# ROCKY TOP RESOURCES

SIGN PLAN

1755 E. LAS VEGAS STREET, COLORADO SPRINGS, EL PASO COUNTY, COLORADO

ROCKY TOP RESOURCES

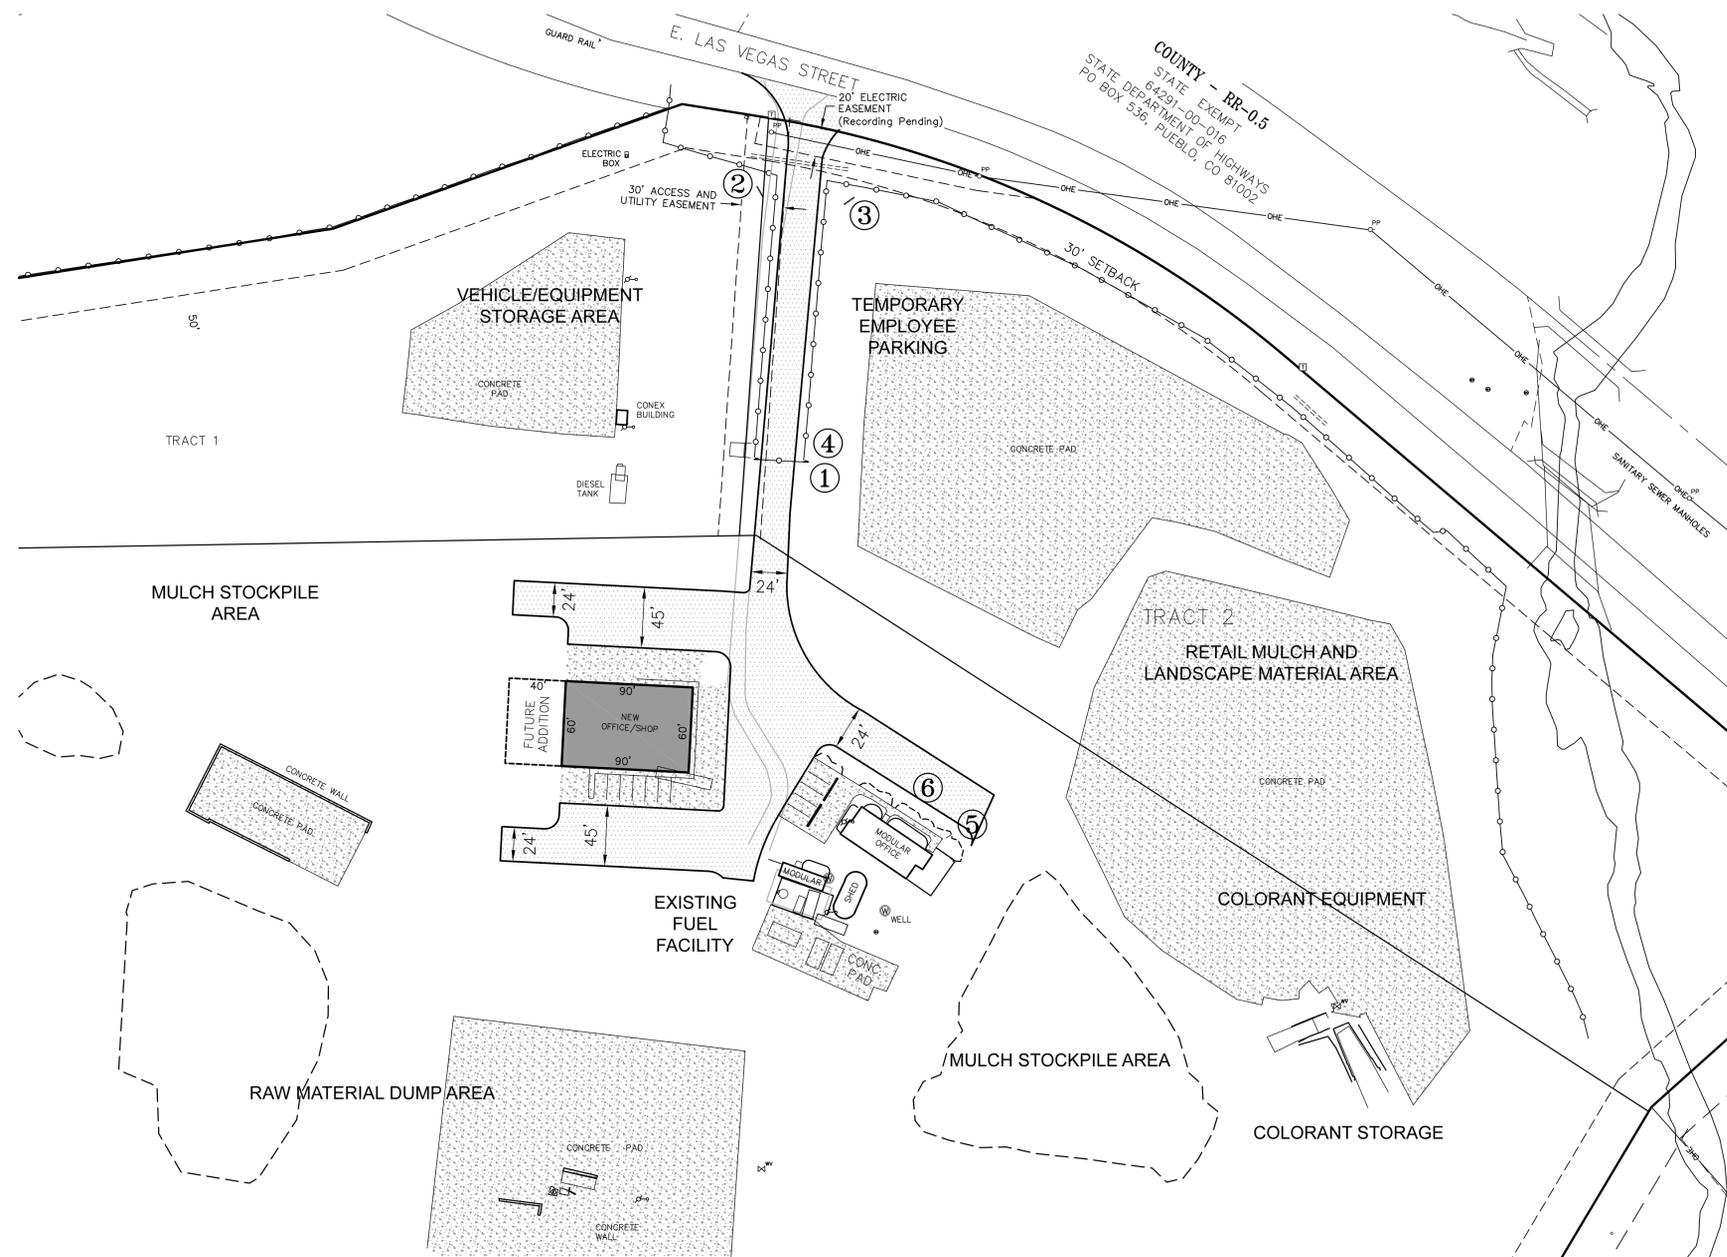
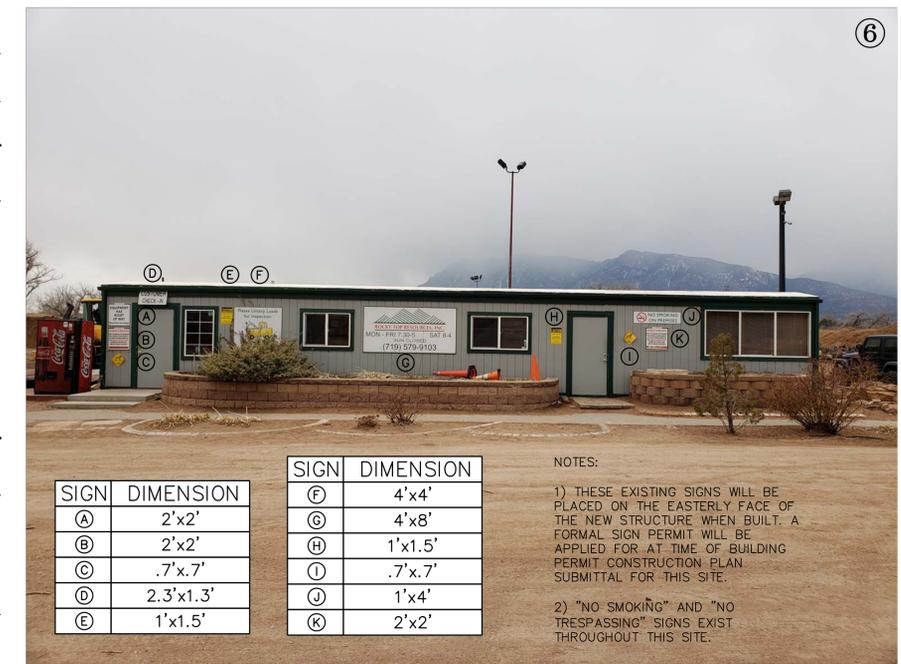
No sign permits currently exist for the site. All sign permits will be required to have a permit per the LDC requirements. directional signs are not required to be permitted. Please update sign plan to indicate which signs are pre-existing.
